SILVERTOWN TUNNEL

8.108 Explanatory Note on Updated Certified Documents

TR010021

April 2017

Figure 4-2: Process for setting the initial user charges

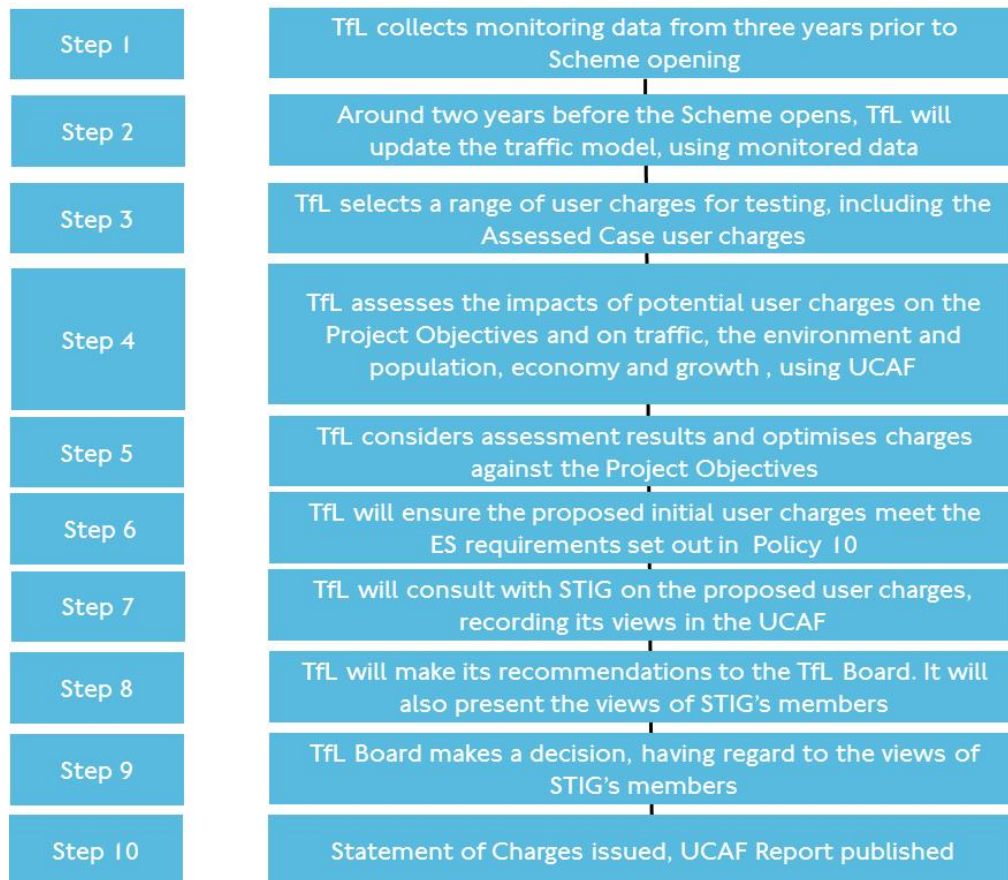
<p>References in the text and in Fig 4-2 to the number a specific DCO Requirement have been replaced with references to Schedule 2, in recognition that numbering of requirements could change in the final version of the DCO. Figure 1-2 has also been updated to take account of this</p>
--	--	--
